Subject: Sears Plat SUB23-001; Mercer Island, WA
Comment Response Letter #4

Thank you for your review of the Preliminary Short Subdivision and SEPA Review applications permit documents and your comments letter dated November 27, 2023. We at Navix Engineering have prepared comment responses below and hope you find the resolution of the review comments acceptable. Please feel free to contact me with any questions or coordination items you have.

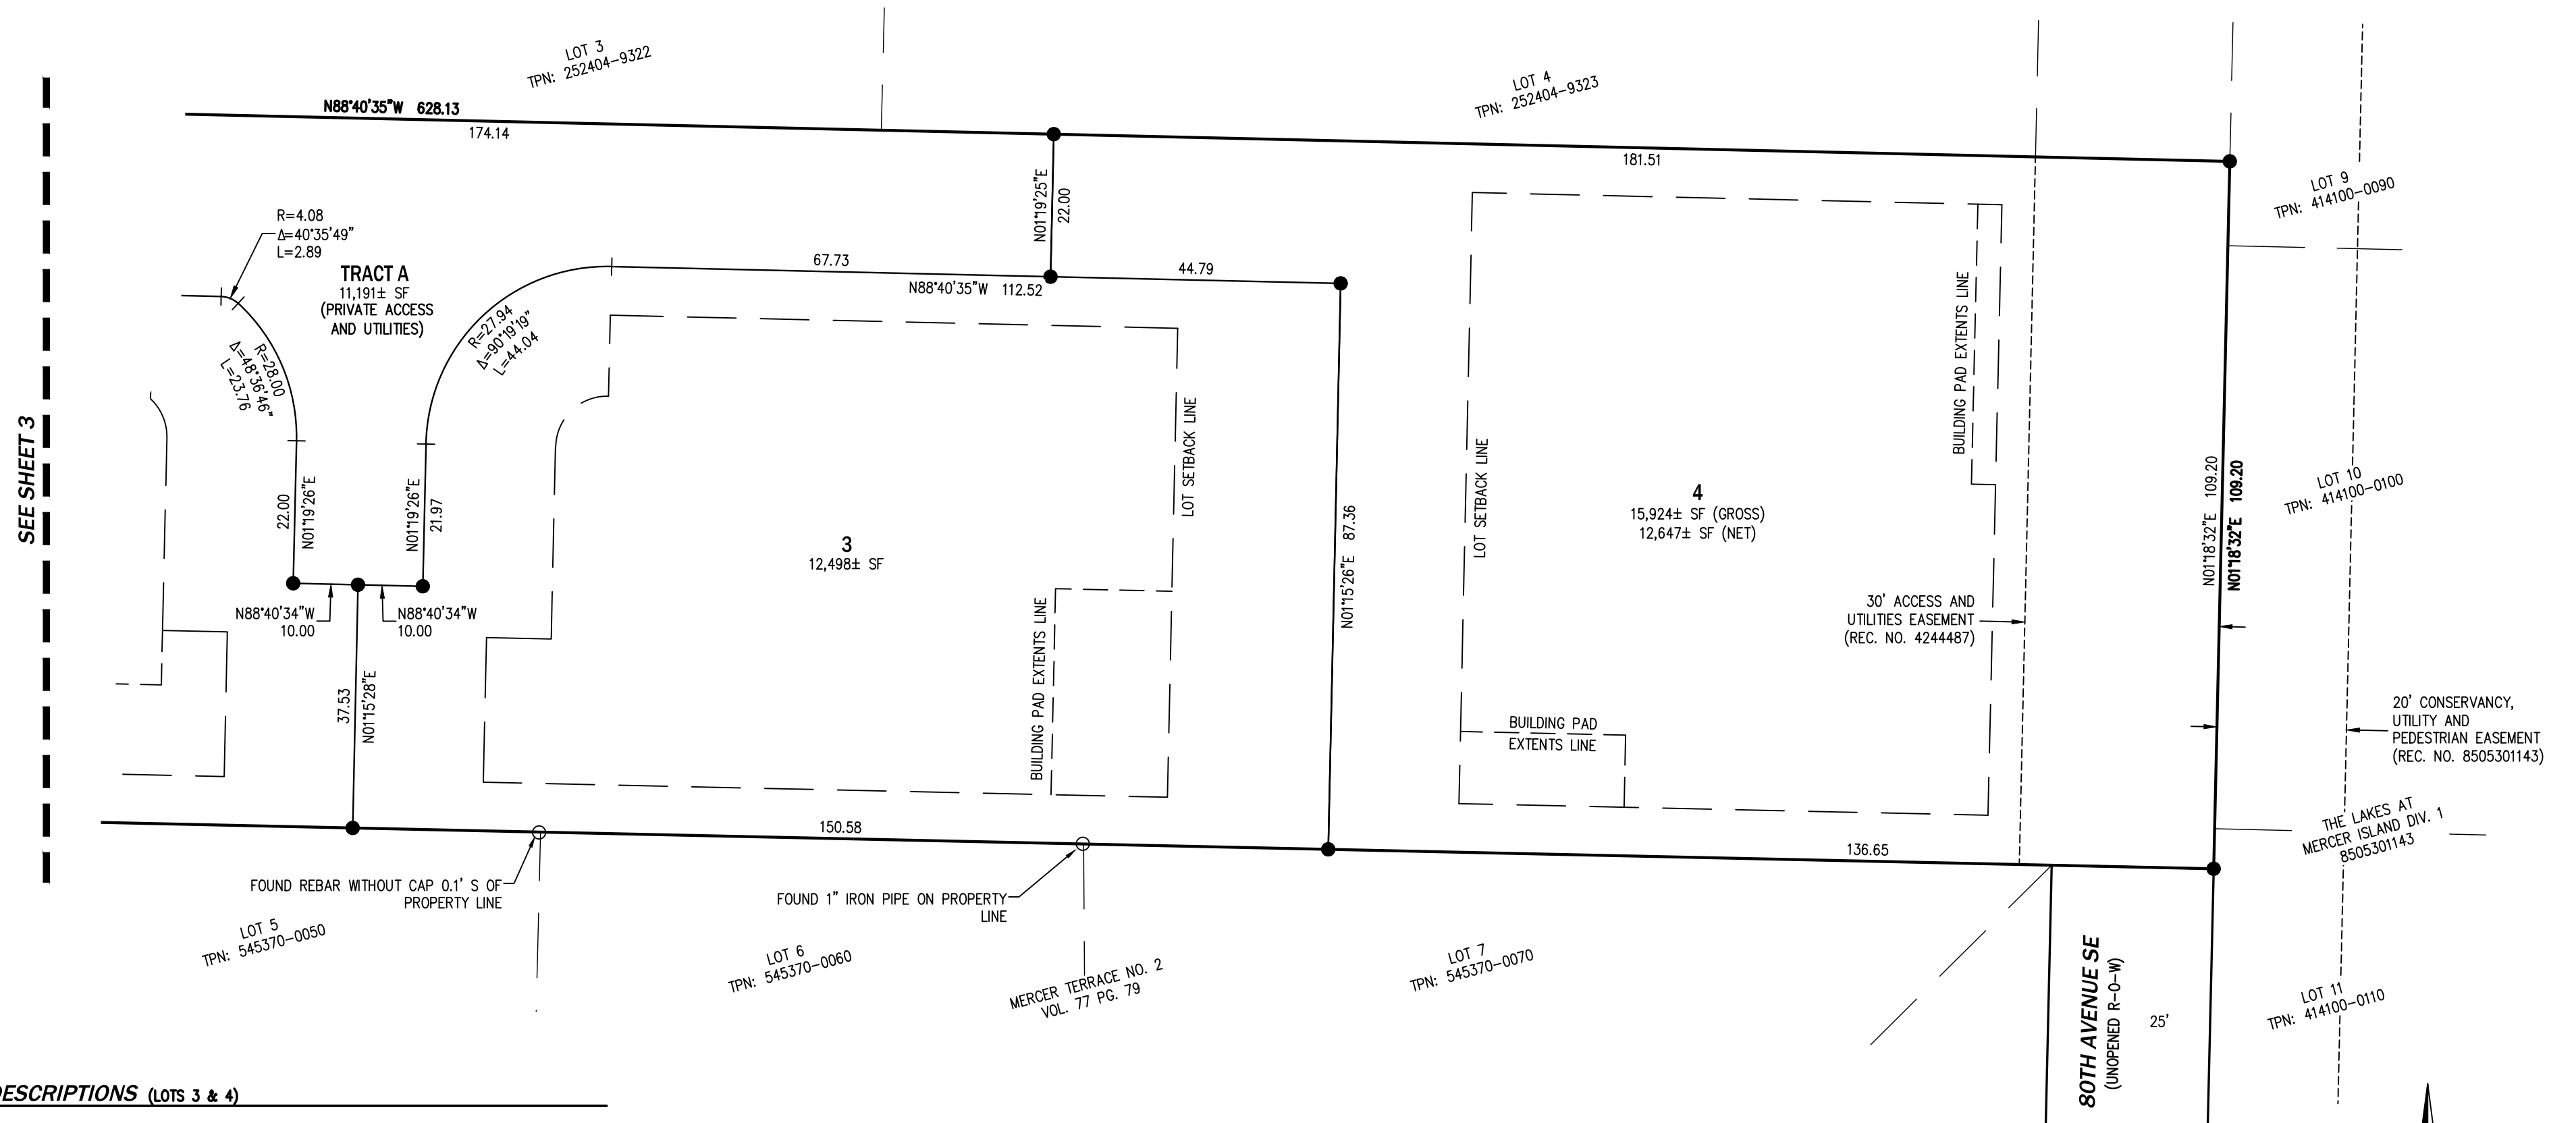
1. Lot 3 is shown to have different areas in the application material. Sheet 4 of the survey and Sheet C4.0 of the civil plan show that Lot 3 will have an area of 12,499 square feet. While the rest of the sheets of the plan set shows that Lot 3 will have an area of 12,498 square feet. Please show the area of Lot 3 consistently throughout the application material. Recheck all calculations and labels to ensure the plan set is consistent throughout.

Response: Lot 3 area on Sheet 4 of the survey has been corrected to show 12,498 square feet.

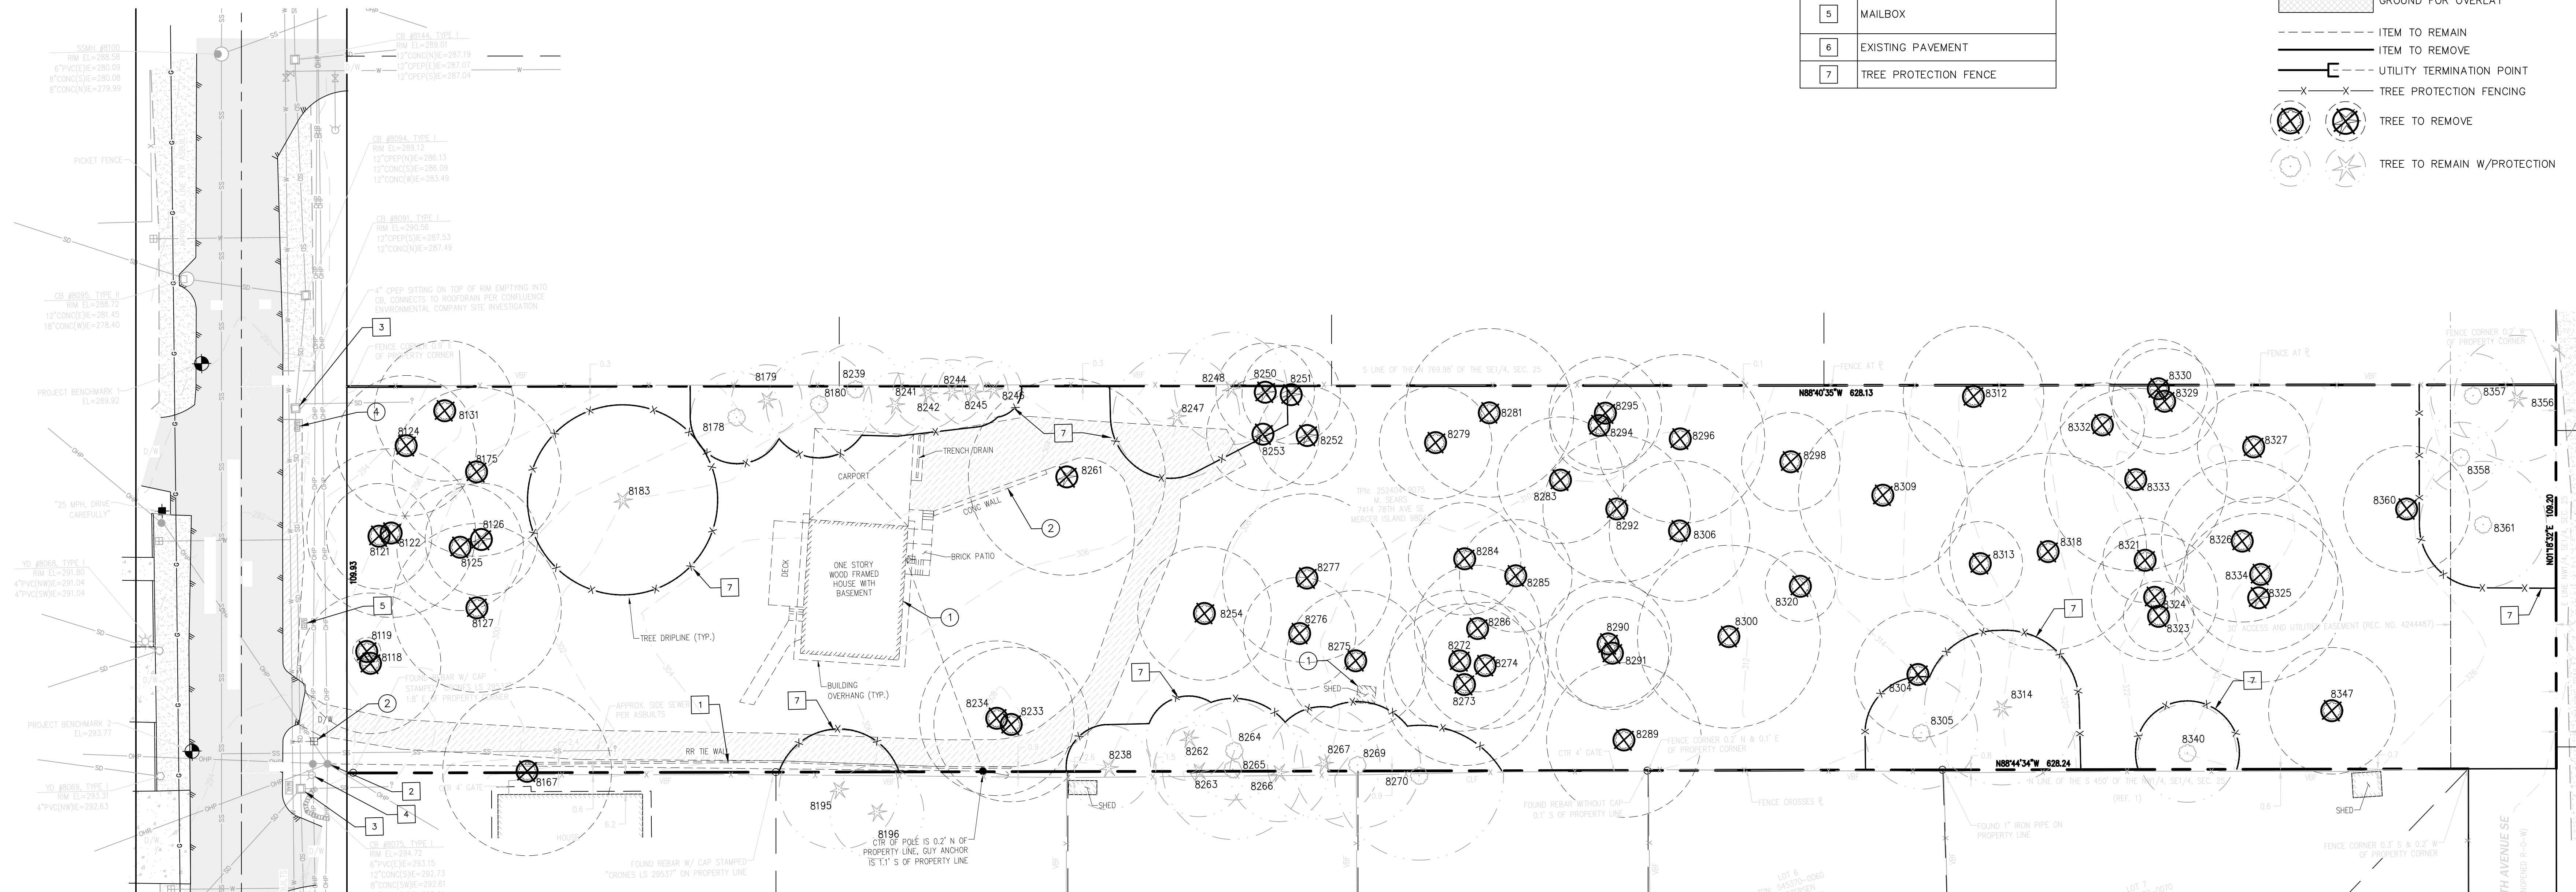
2. MICC 19.09.090(A)(1)(a) requires that building pads shall be located to minimize the removal of trees and impacts to trees and vegetation required for retention. Please revise the building pads to account for impacts to trees and vegetation as per arborist comments below.

1. The provided tree inventory worksheet and the table in the arborist report and site plan do not match. Some trees are listed as exceptional in one document, but not the other. The tree inventory worksheet lists tree 8234 as exceptional, but the arborist report does not (The tree table in the arborist report and plan set colored tree 8234 as an exceptional tree. If color coding in the table is relevant, please include a color key). Please revisit the arborist report, site plan, and tree inventory worksheet to ensure that they are consistent with each other.

Response: The building pads have been updated to provide a minimum of 5 feet from the drip lines.

Response: All documentation about the trees has been updated to be consistent.
